Addendum No. 1

RE: Contract ID: C202427

Forsyth County (B-4745)

Bridge Over 20th Street and Approaches On SR-1725 In Winston-Salem

REVISIONS						SHEET NO.
NO.	BY:	DATE:	NO.	BY:	DATE:	S-3
1			3			TOTAL SHEETS
2			4			38

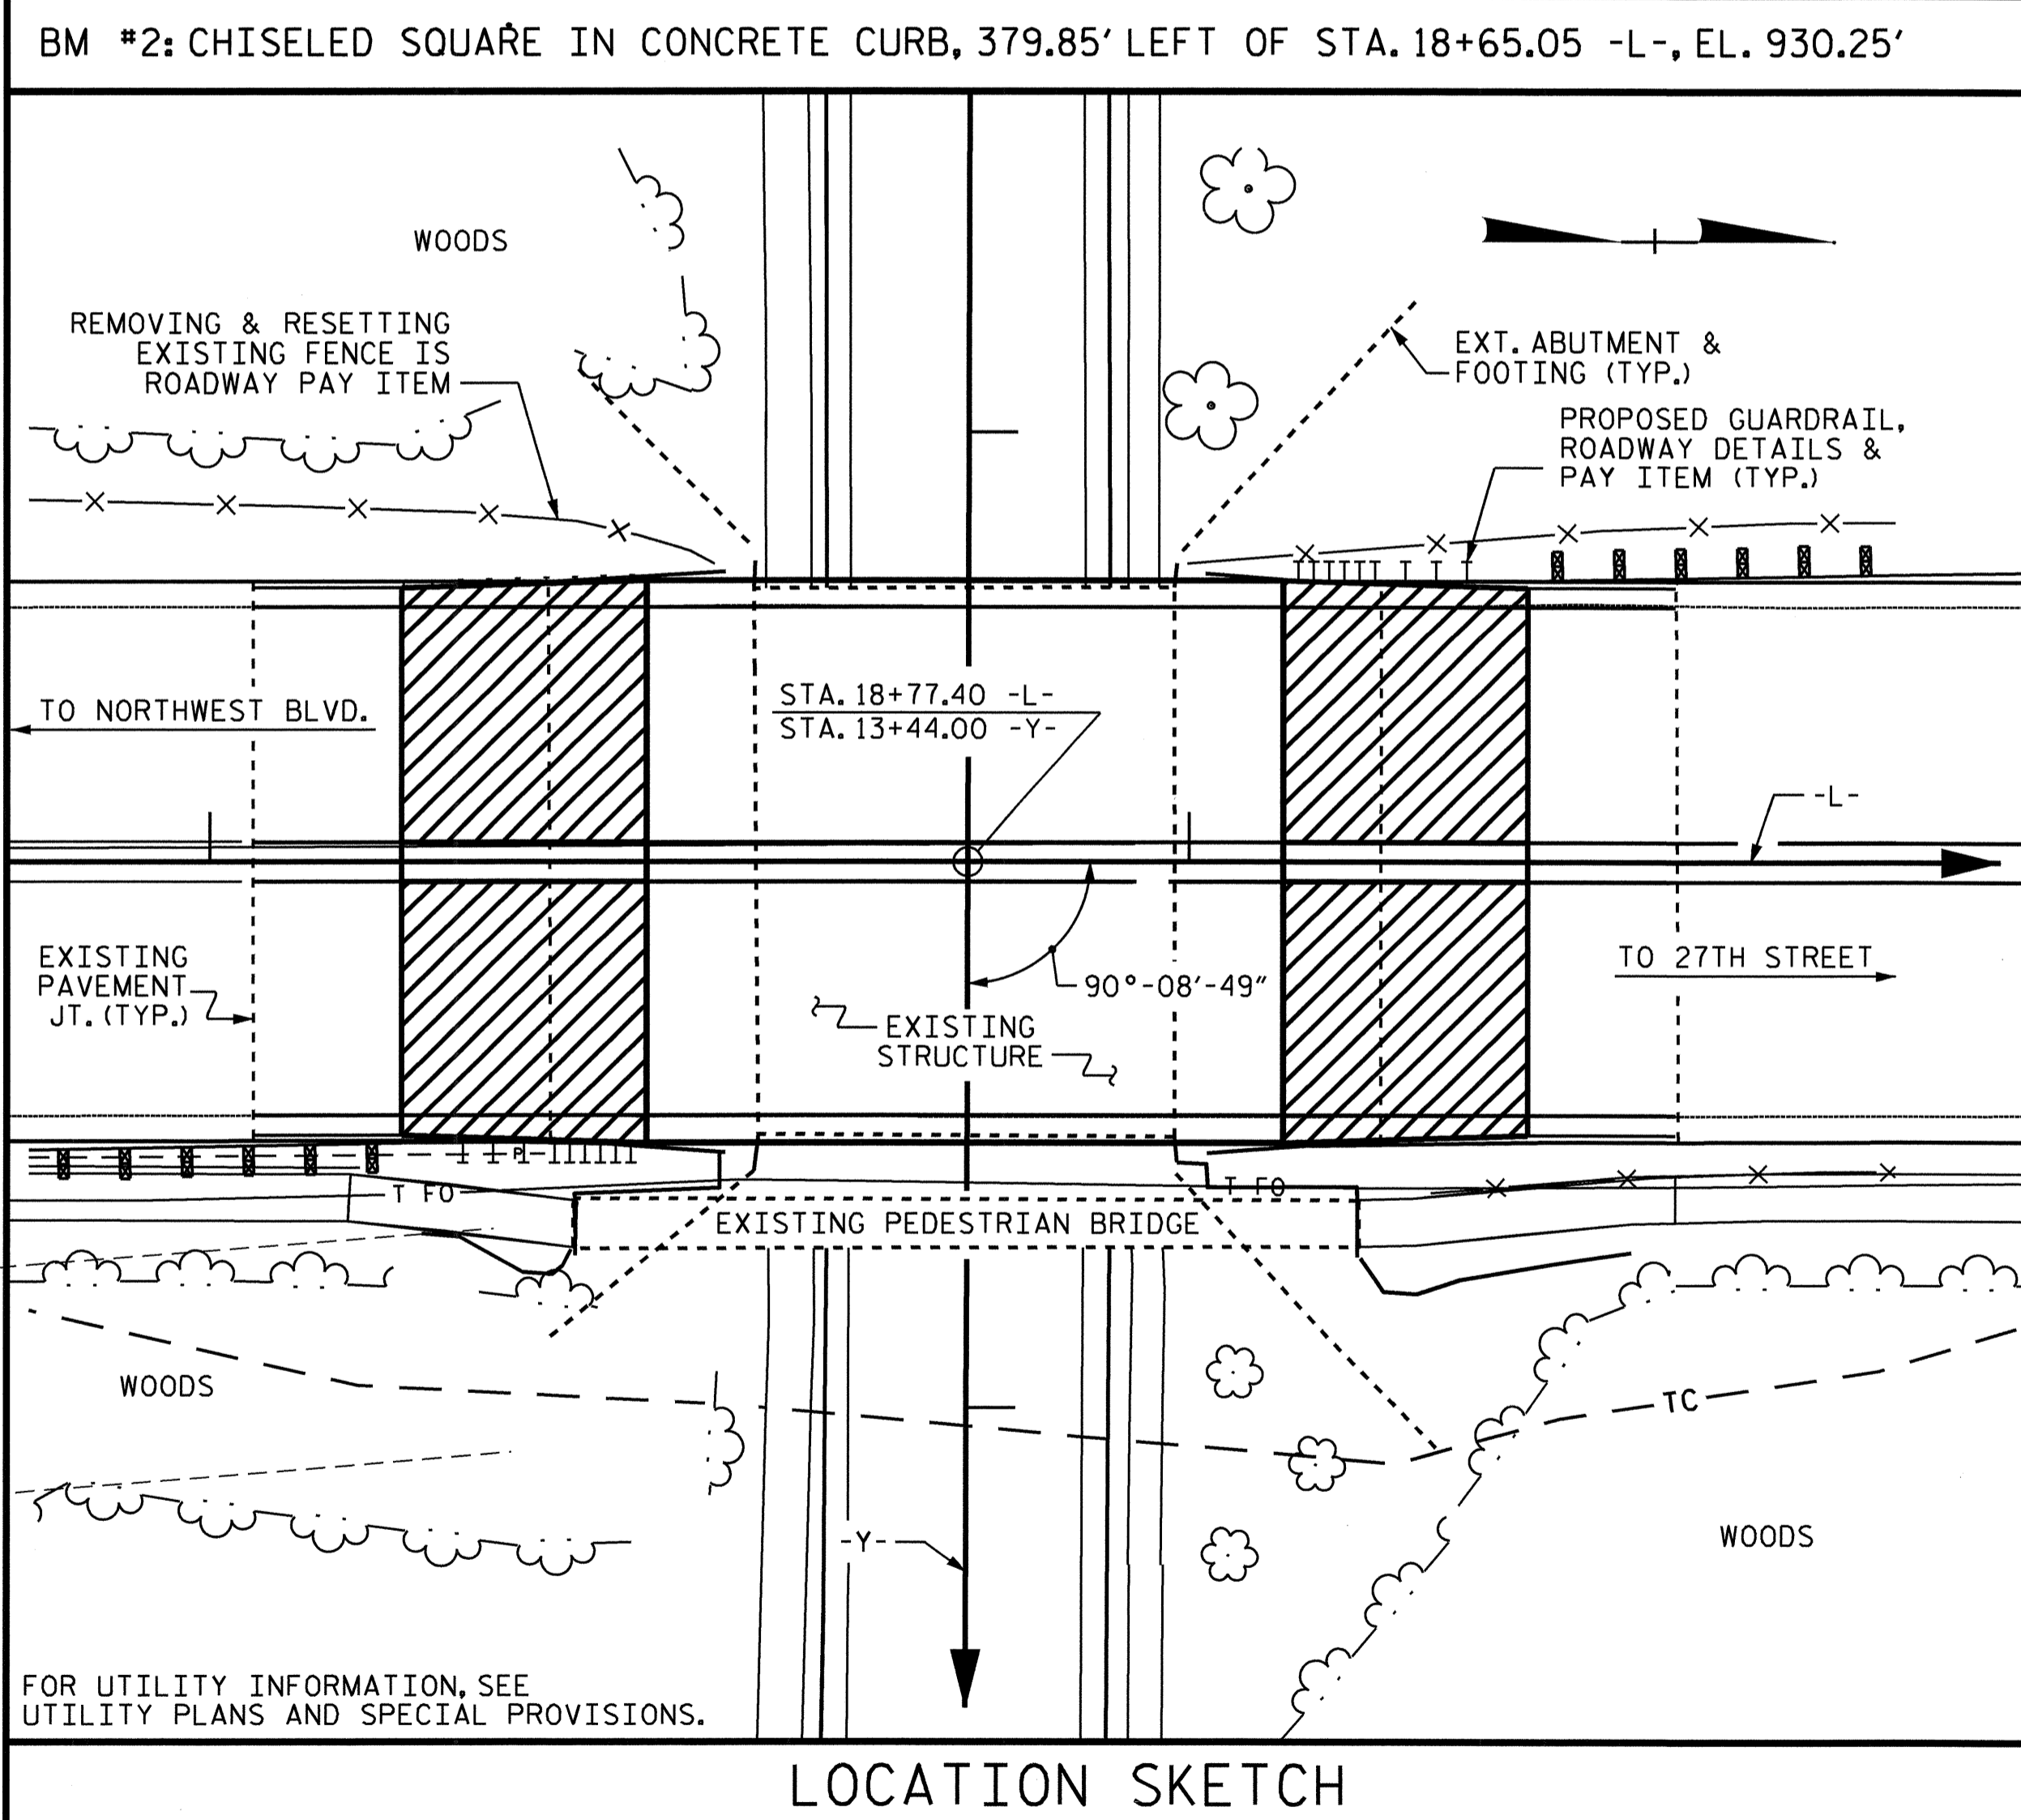
Sheet No. S-3 has been revised to change the pay quantity for "Bridge Deck Grinding" in the "Total Bill of Material". Please void Sheet No. S-3 in your plans and staple the revised Sheet No. S-3 thereto. On Sheet No. S-14 a note has been added concerning bridge deck grinding. Please void Sheet No. S-14 in your plans and staple the revised Sheet No. S-14 thereto.
